## **RESPONSE TO SUBMISSIONS: PROPOSED MANUFACTURING FACILITY AND ASSOCIATED WAREHOUSE**

657-769 MAMRE ROAD, KEMPS CREEK  
LOT 10 APPROVED UNDER SSD 9522

**7 September 2022**

SSD-25725029

LANDSCAPE CONCEPT PLAN

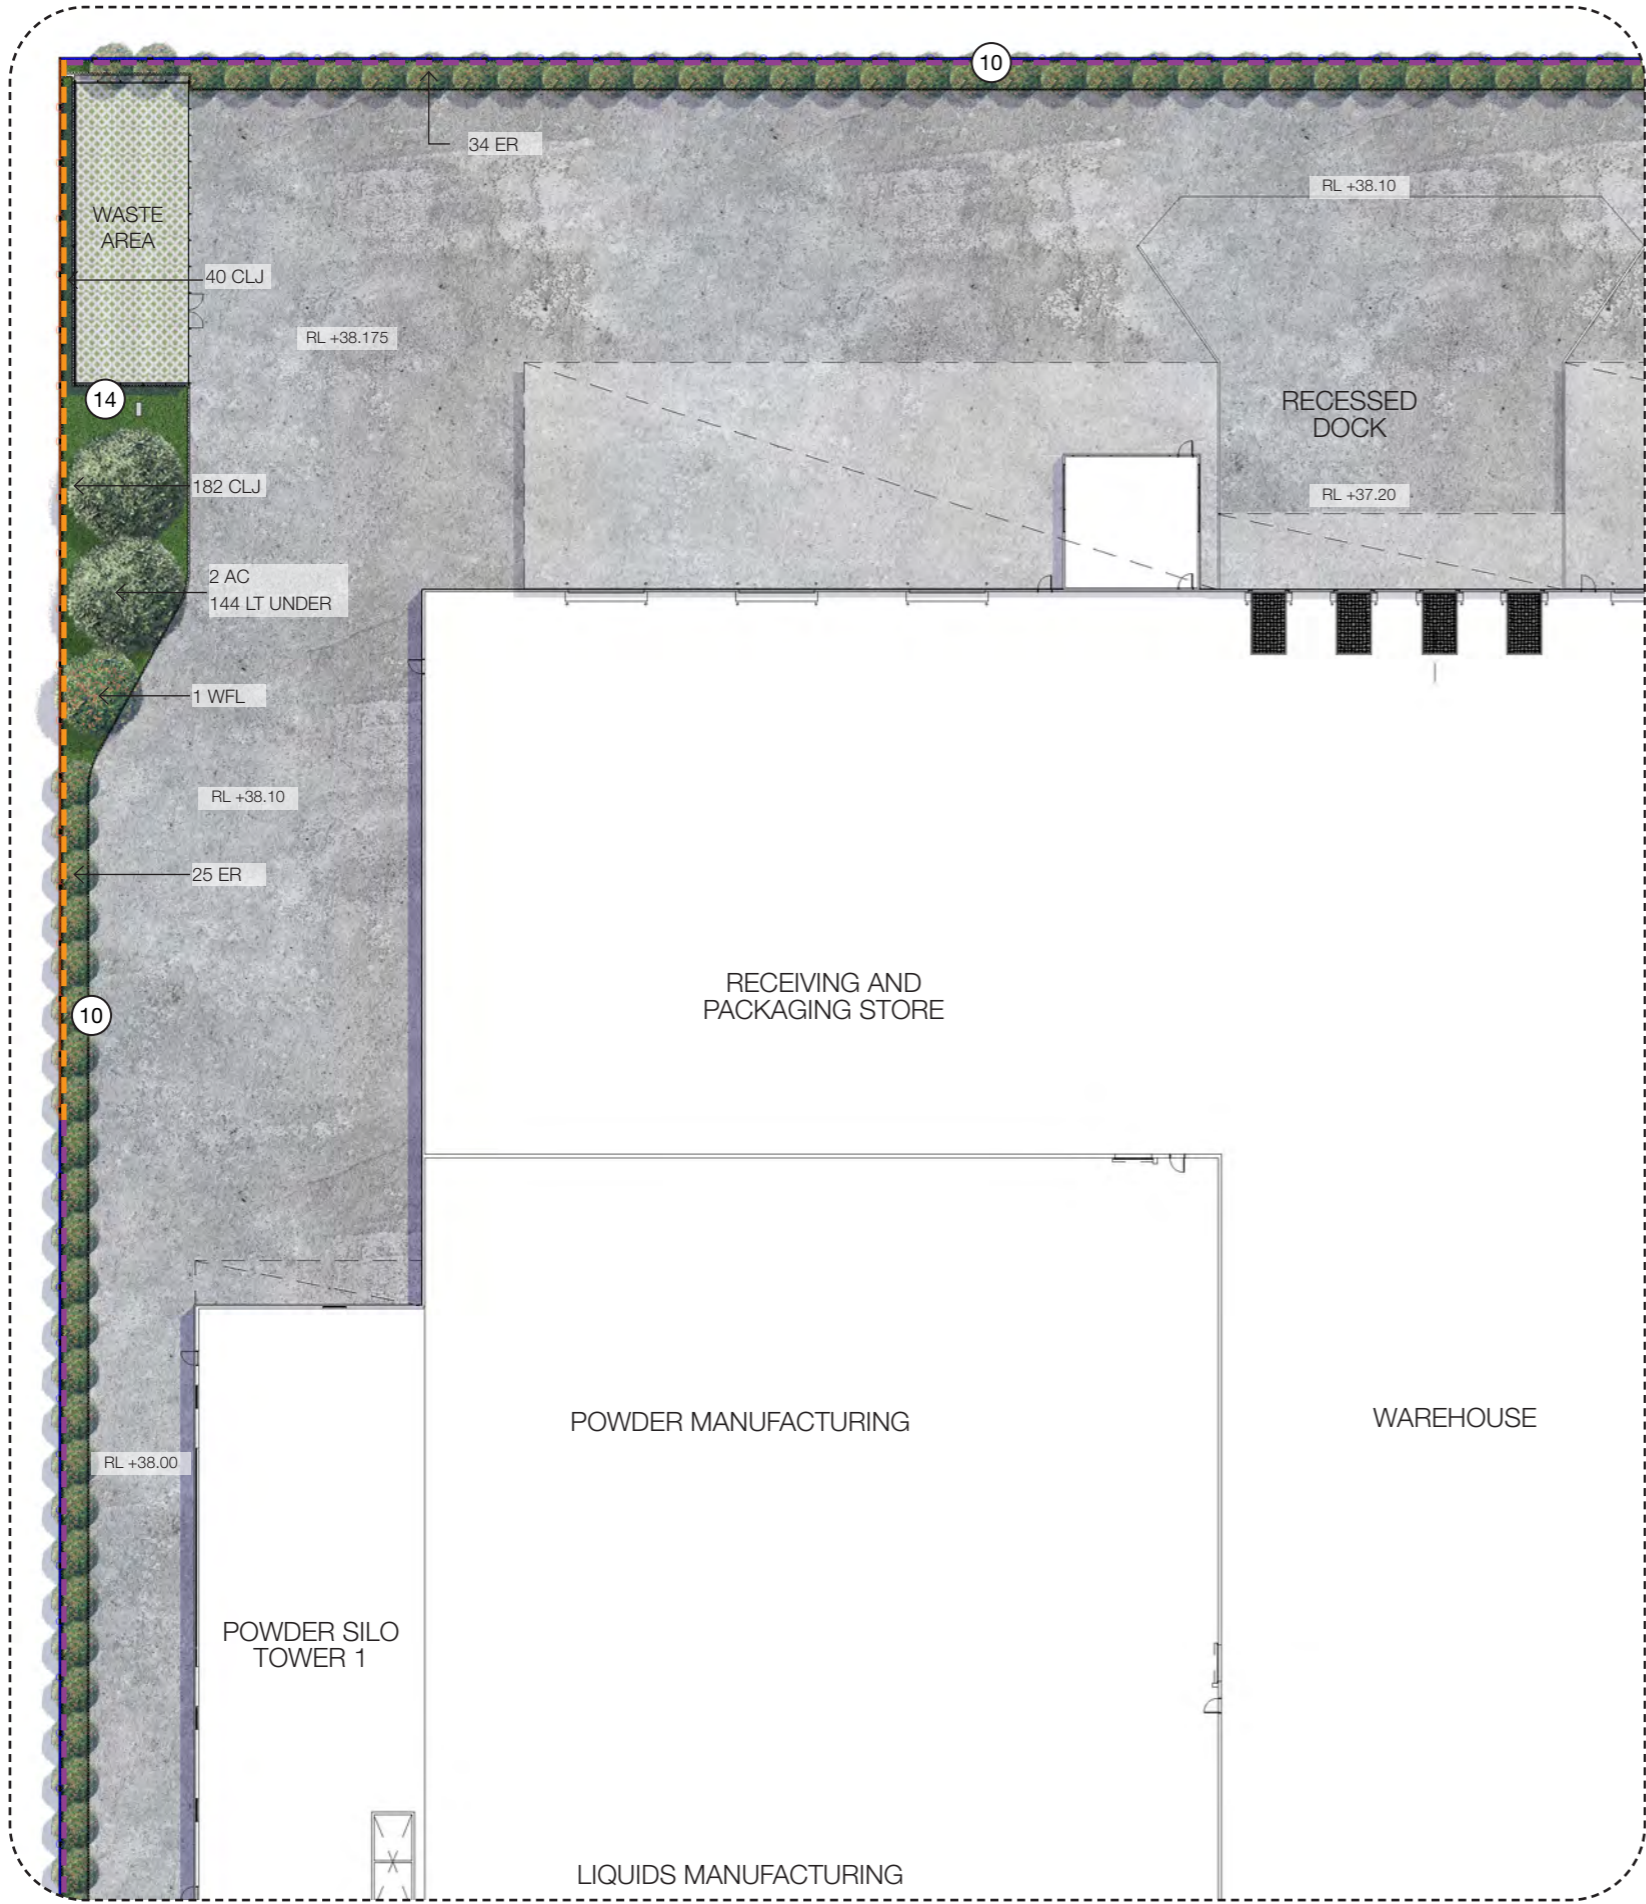
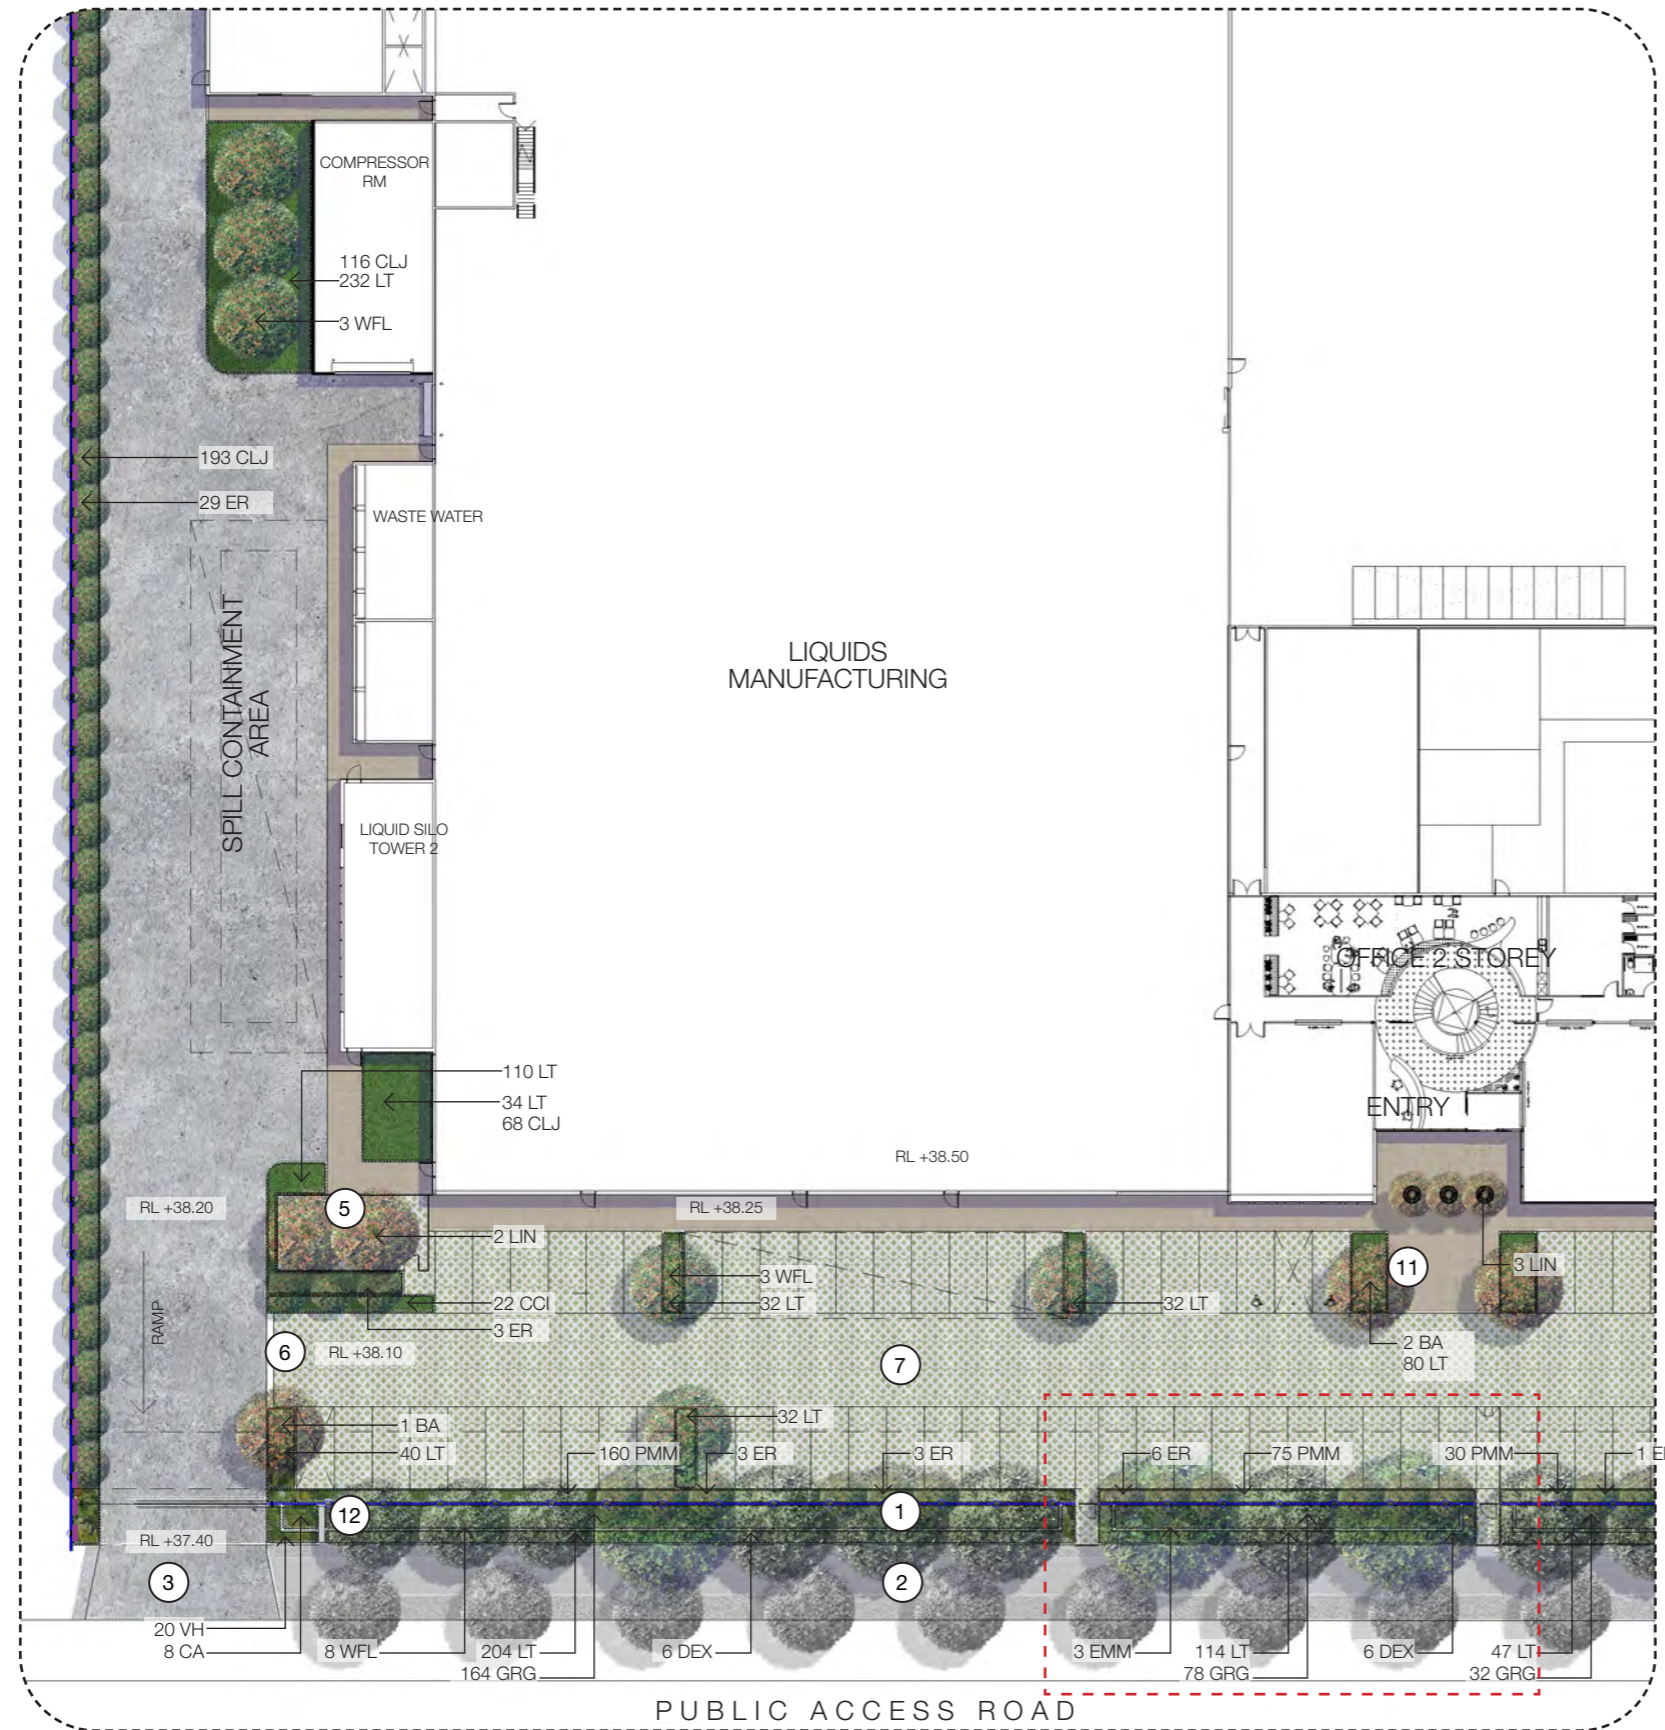
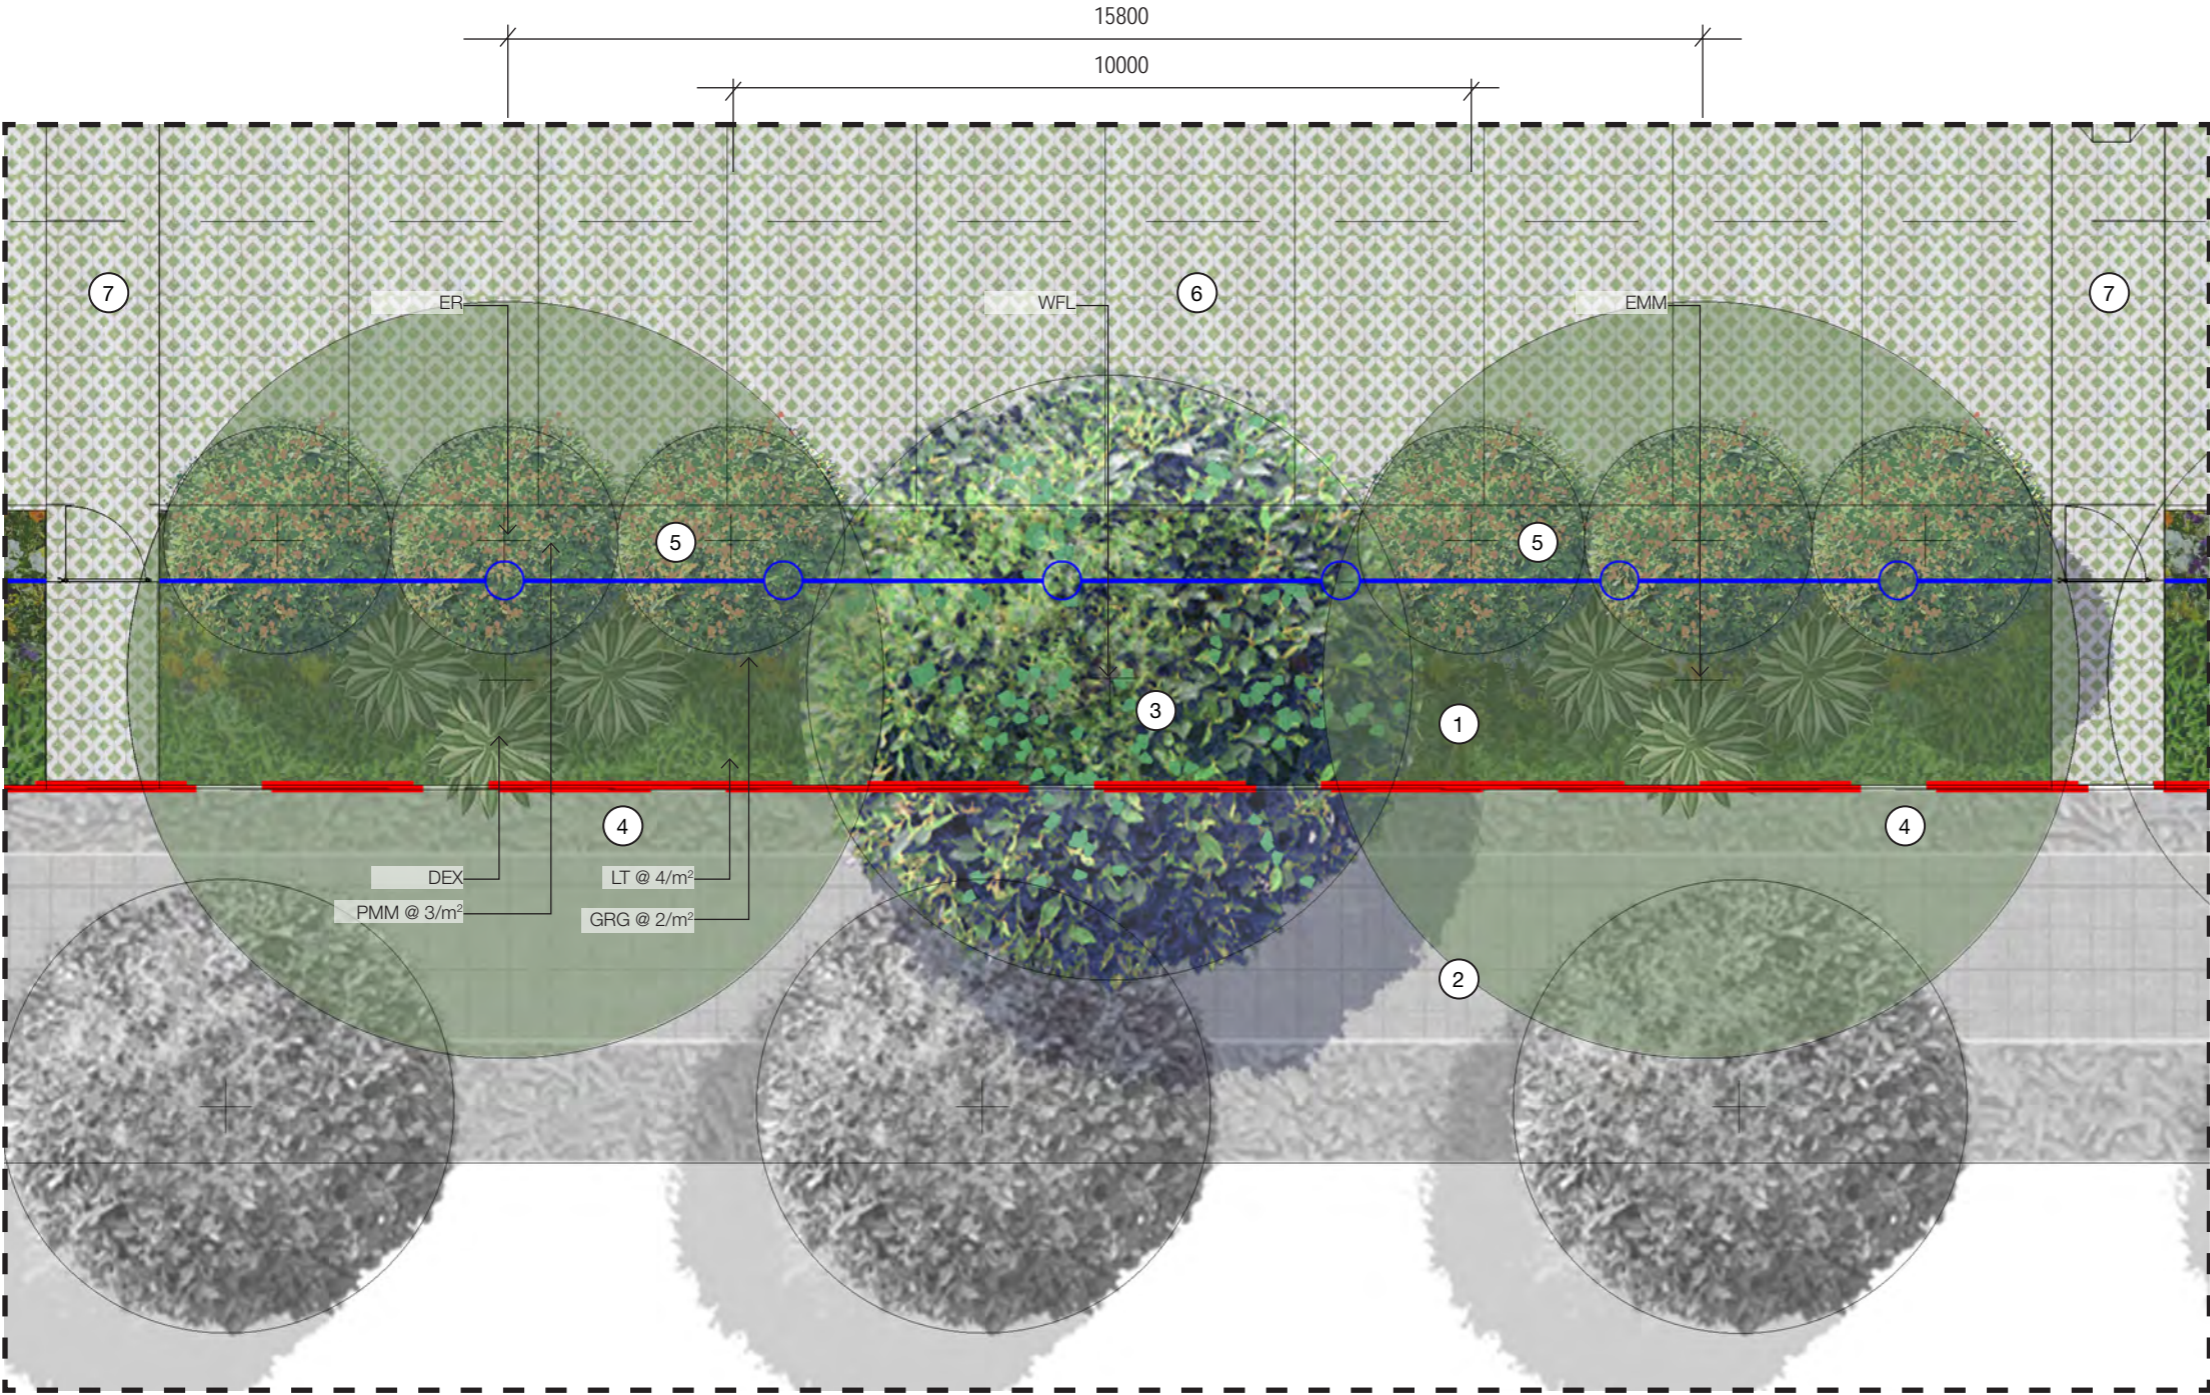
SUBMITTER	MATTERS RAISED	COMMENTS / REQUESTS	FORMAL RESPONSE
			Therefore, it is believed that in this case the request would result in an imperceivable change in the view from any of the locations within the VIA.
		The VIA relies on vegetation plantings to screen the proposal. Please confirm on a plan which landscaping is approved under SSD-9522, which is proposed as part of this development and what landscaping is outside of the subject site.	The vegetation and screening shown within the photomontages is described within Sections 2.8 & 2.9 of the VIA with a tabulated breakdown including other approved or future developments. All proposed landscape design has been incorporated for each development listed in the VIA and adjusted to suit the relevant timeframe of each image. This was achieved by referring to landscape documentation produced by Habit8. Landscape drawings are included in Section 7.0 of the VIA; however, all other plans were sourced from and available in their respective applications (SSD-9522 MOD 1 and SSD-10101987).
